DECISION DELEGATED TO DEVELOPMENT MANAGER**DECISION DELEGATED TO DEVELOPMENT MANAGER**

Application No: H13-0392-21 **Applicant:** Mr L Salter

Proposal: Proposed double garage and games room/gym with annexe above and swimming pool extension

Location: 14a Broad Lane Moulton Spalding

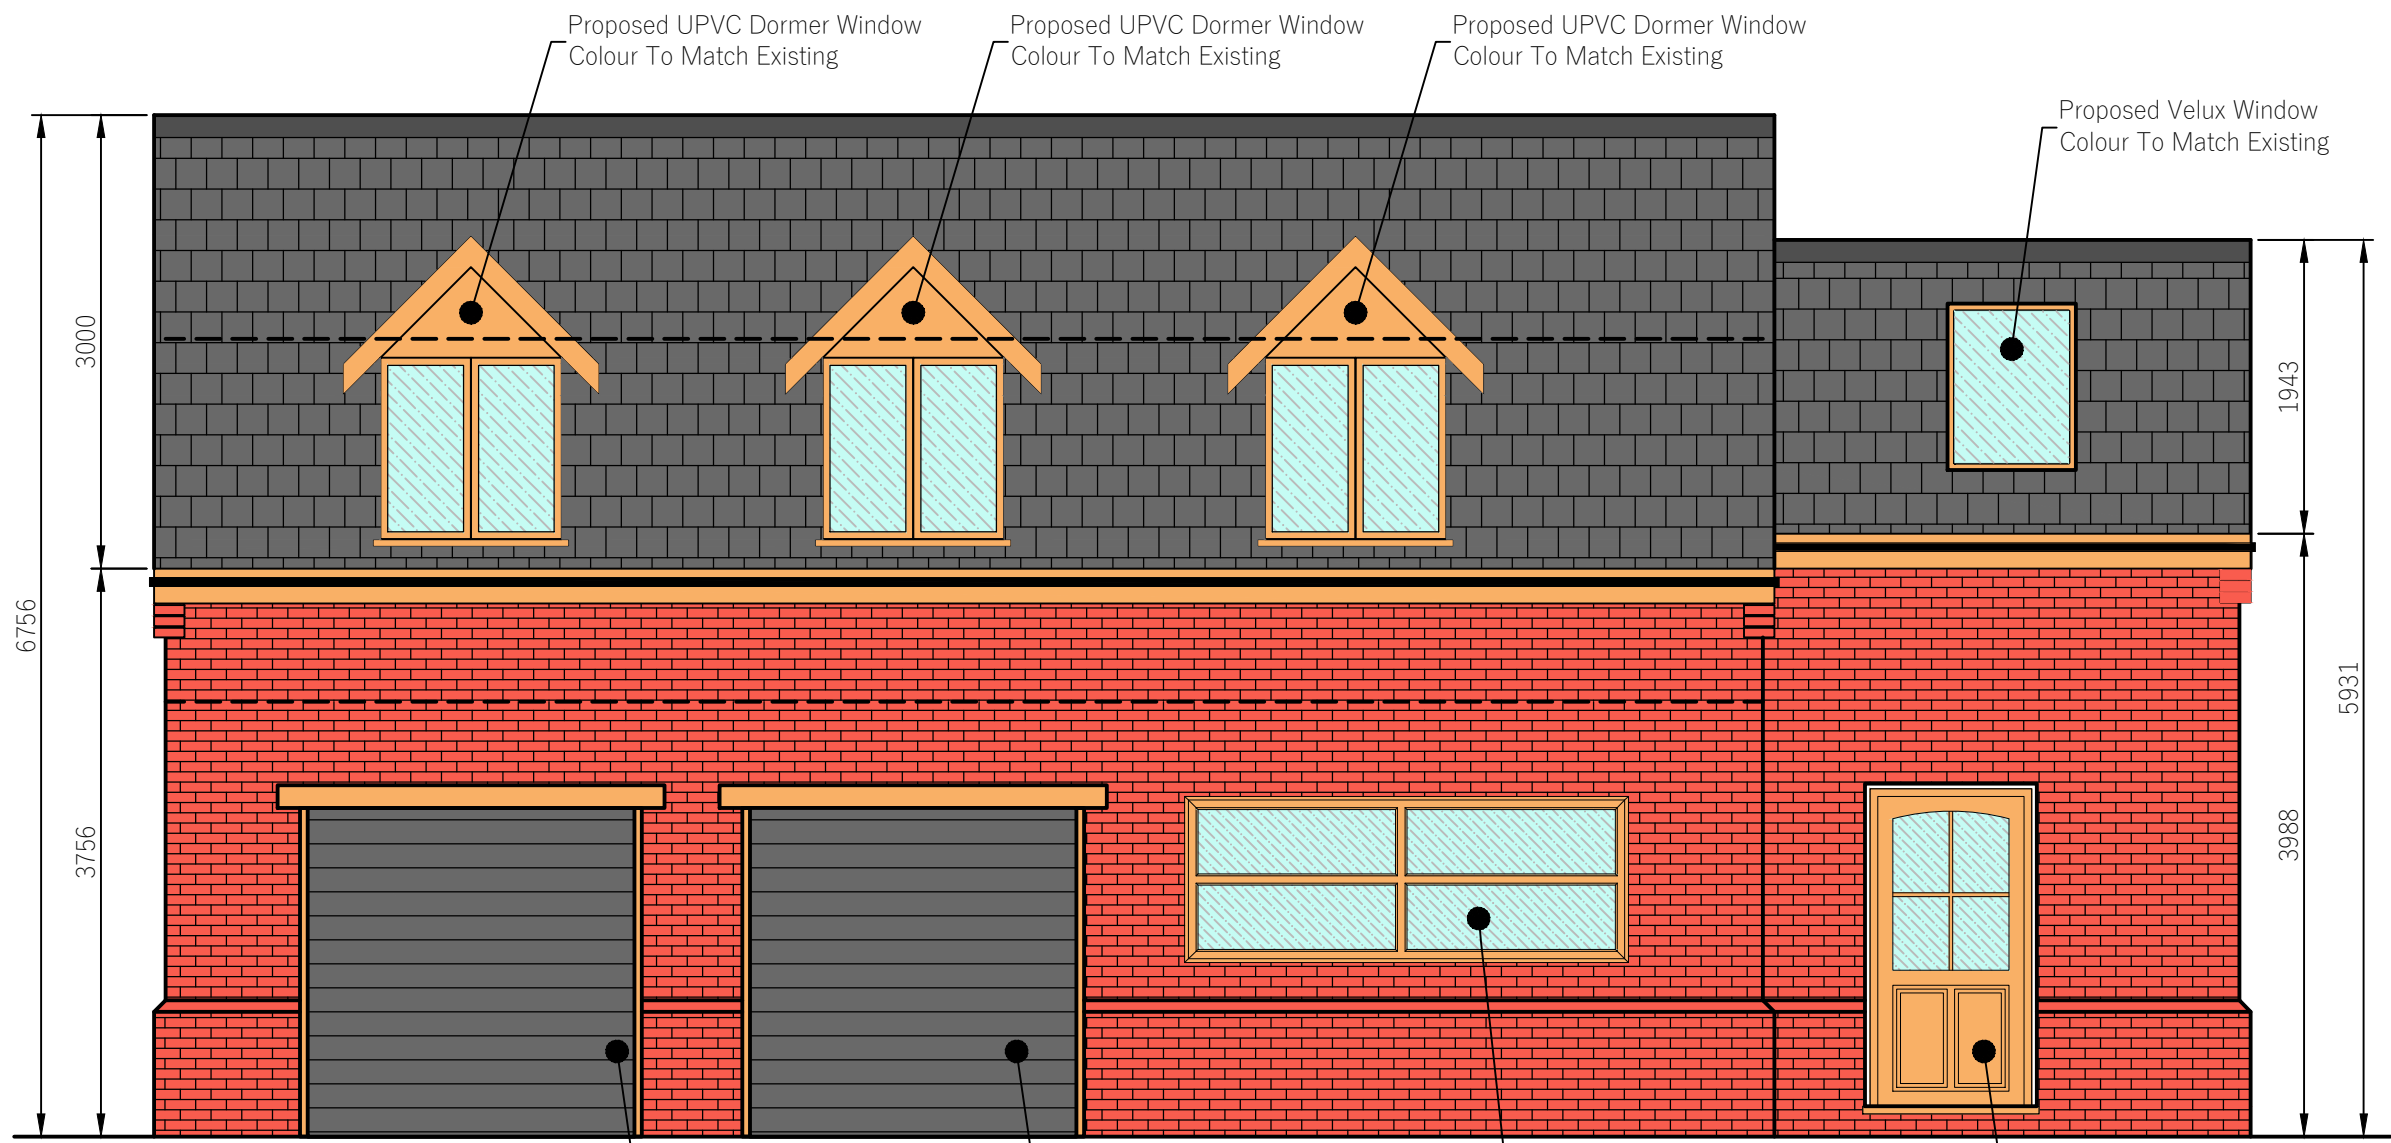
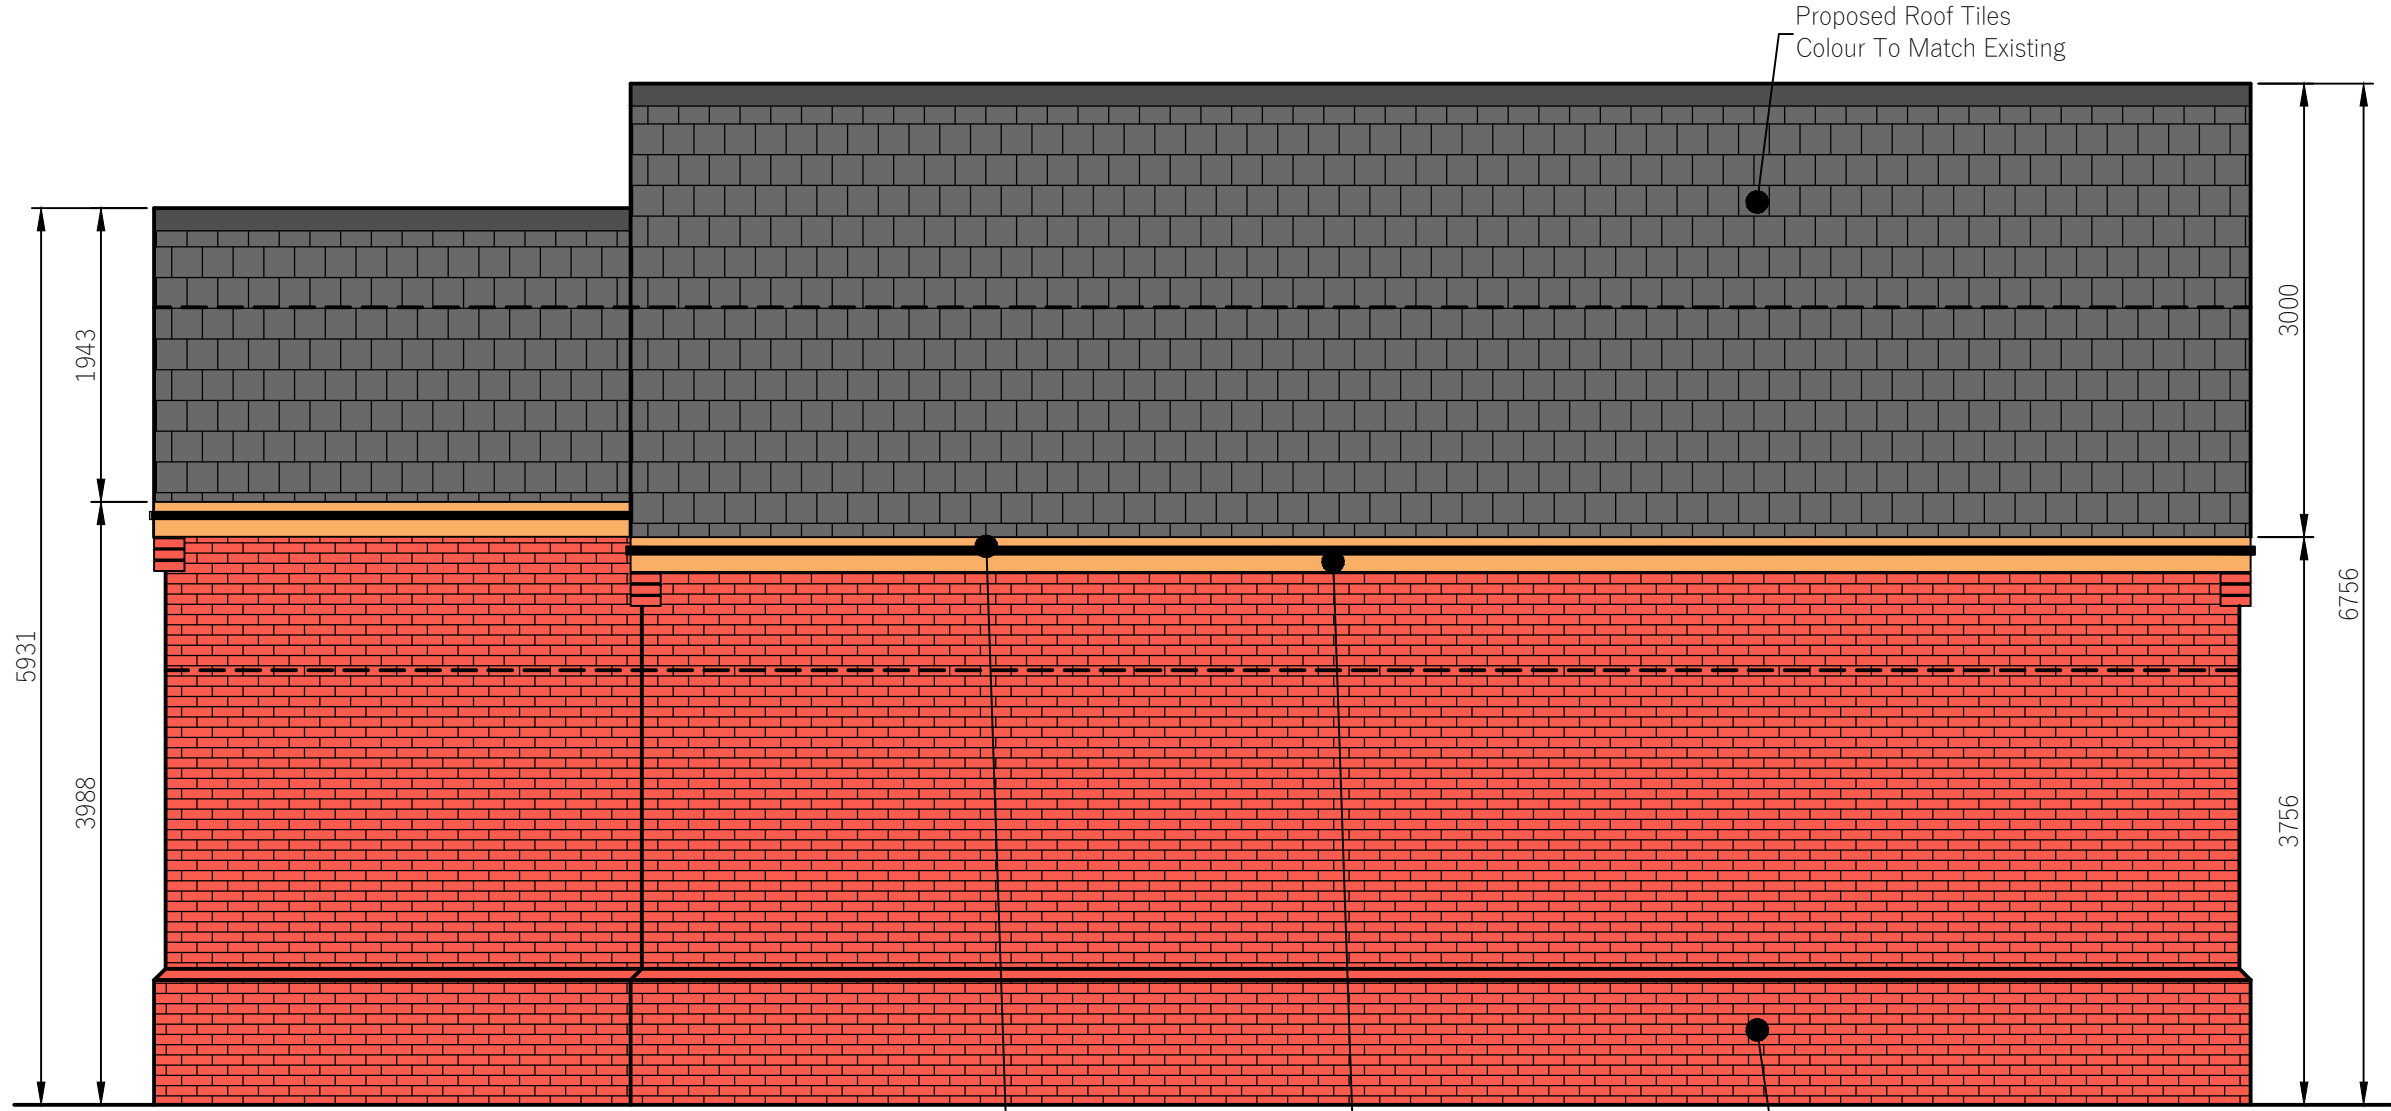
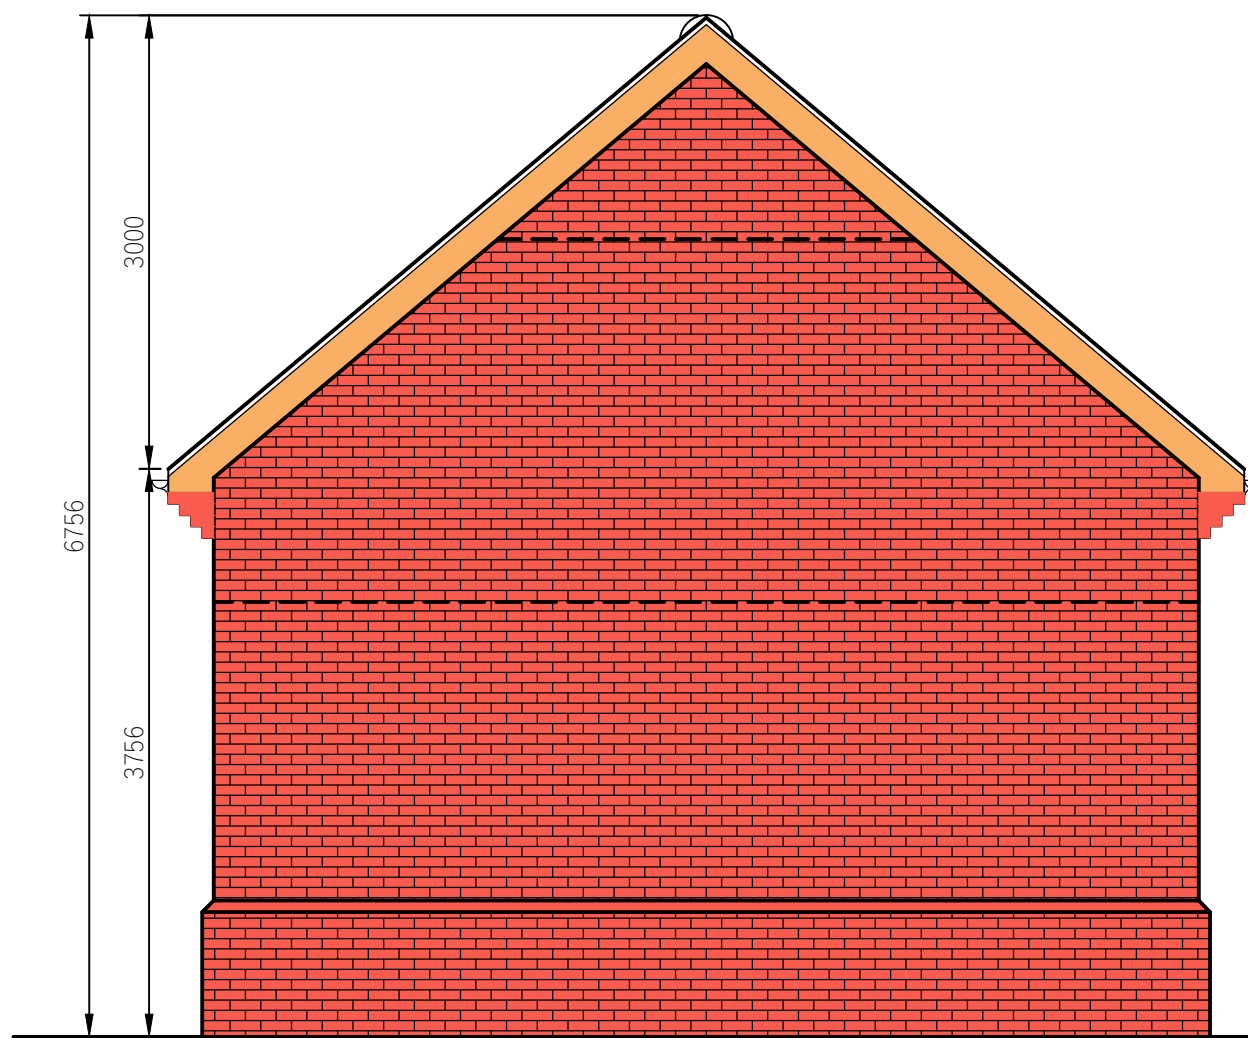
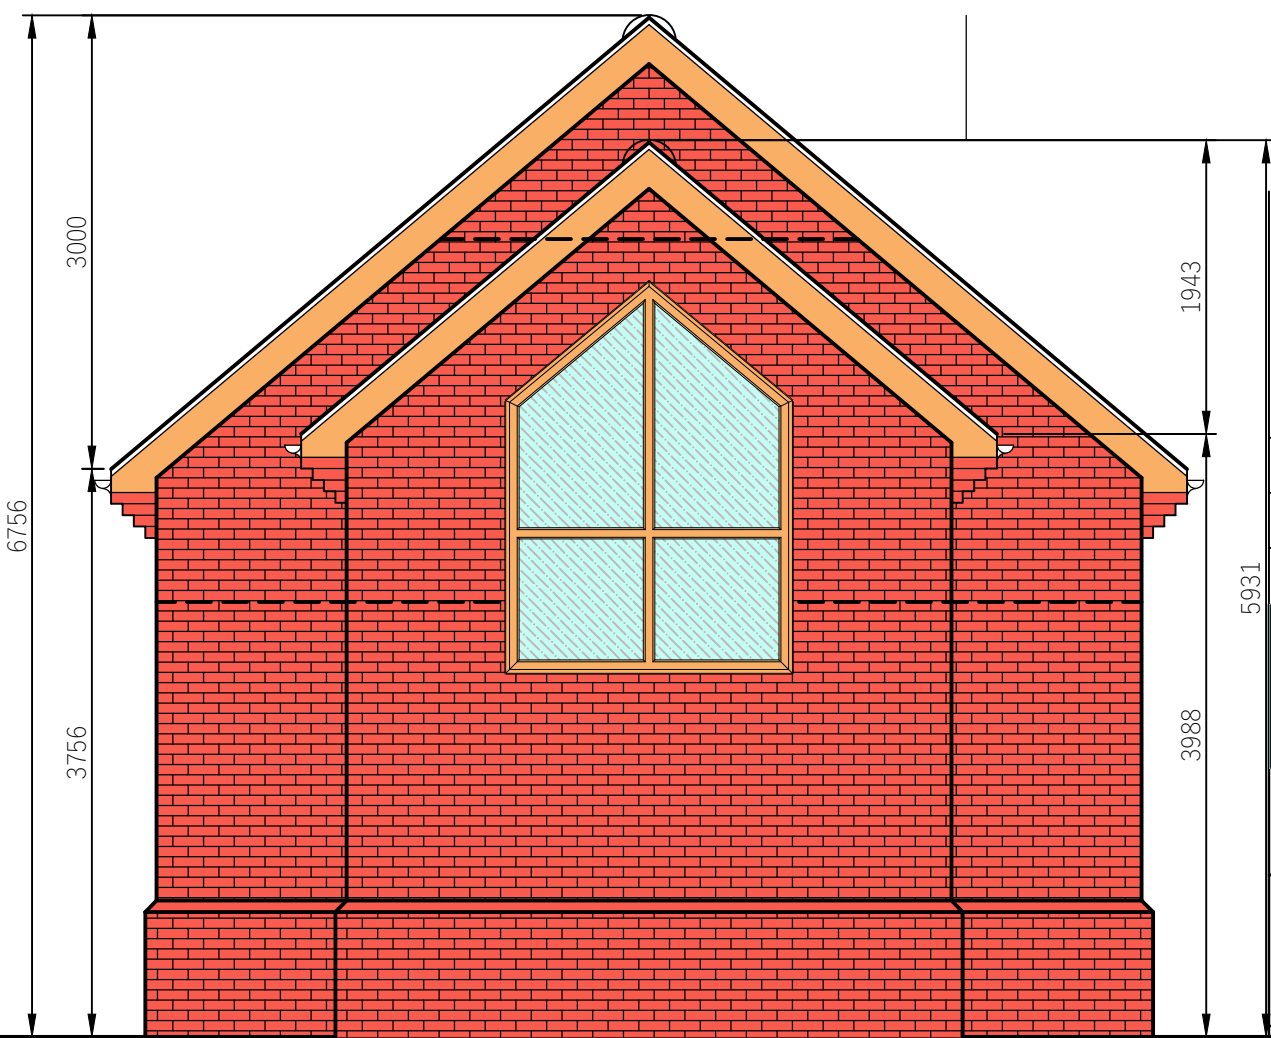
- Failure to notify neighbour of application
- Inaccuracies within the application regarding trees. It is not clear if any trees are being removed
- The proposed building will result in overbearing impact
- Overshadowing and loss of daylight
- Reduced efficiency of solar panels

The neighbour at no.3 Hawthorn chase located to the north of the application site also objected to the proposal on grounds of failure to notify neighbour of application, inaccuracies within the application regarding trees (it is not clear if any trees are being removed), the proposed building will result in overbearing impact, overshadowing and loss of daylight and reduced efficiency of solar panels due to loss of sunlight.

The concerns are noted and regarding the first point about failure to notify this neighbour of the application, this was due to a system error. Following the concerns raised by this neighbour a full re-consultation was undertaken to allow all relevant parties a chance to comment on the application. With regards to the trees along the shared boundary the applicant has stated that these are not proposed to be removed. A condition has been appended requiring the retention of the trees along the northern boundary to protect the amenity of this neighbour. The proposed building would be located approximately 2 metres from the boundary therefore these trees are not considered to be impacted. The proposed building is not considered to result in overbearing impact or unacceptable overshadowing/loss of light on this neighbour given the roof would face away from this neighbour, thereby reducing the impact. In addition, the site is well enclosed by high level trees/hedges therefore the majority of the building would not be visible to this neighbour. With regards to the concerns raised regarding loss of daylight and reduced efficiency of the solar panels, again the concerns are noted, however it is not considered that any unacceptable impact would result from the proposed development as there are high level trees along the northern boundary of the site and the proposed outbuilding would not be higher than the trees. As such any impact in terms of loss of daylight would be from the existing trees.
